Application No: R/255/21/T
Site Address: Old Orchard House 47 The Street Rustington BN16 3NU
Description of works: Various works to various trees.

Thank you for your internet representation made on 6th November 2021 which has been recorded as support with the comments as follows:

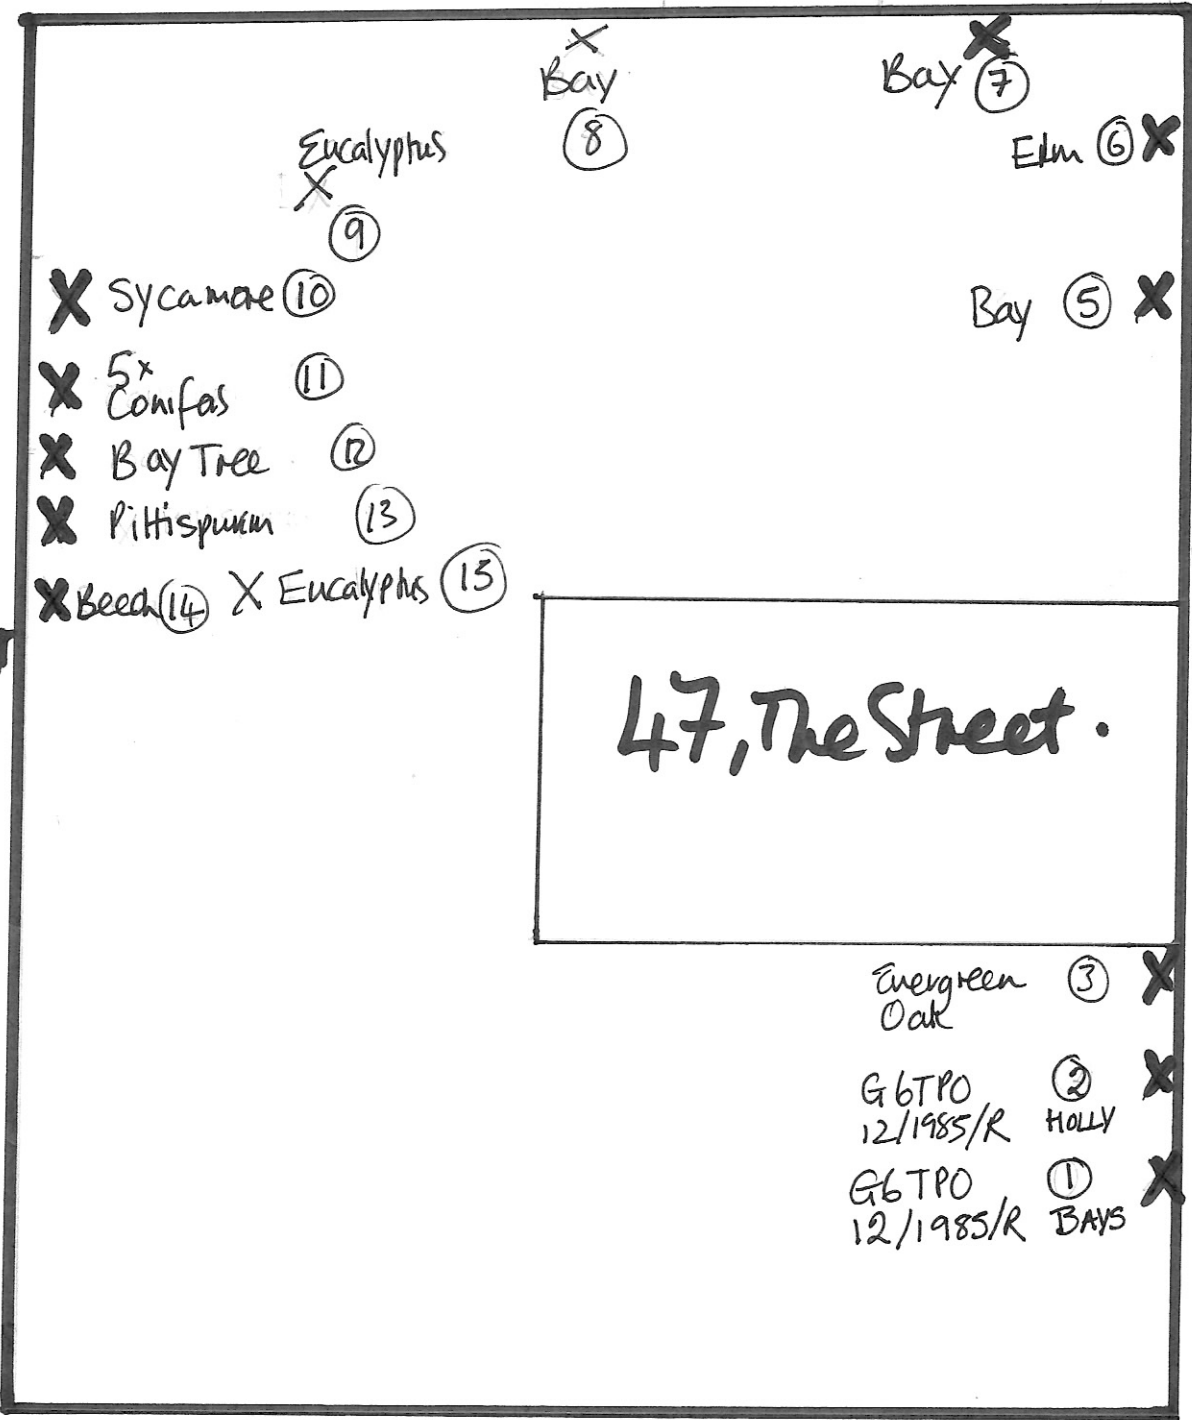
The trees and hedging numbered 10 to 15 on the plan border the Northern boundary with our property. They are very large, unkempt, not well shaped and overhang our property. In particular tree 10 the Sycamore overhangs the roof of our property substantially and as a result we have had to have excessive moss removed from our roof and regularly have to clear fallen debris from the roof as well the gutter to prevent it becoming blocked. Several of the trees towards the Eastern end of our property overhang our garage roof and deposit debris onto the roof and into the gutters.
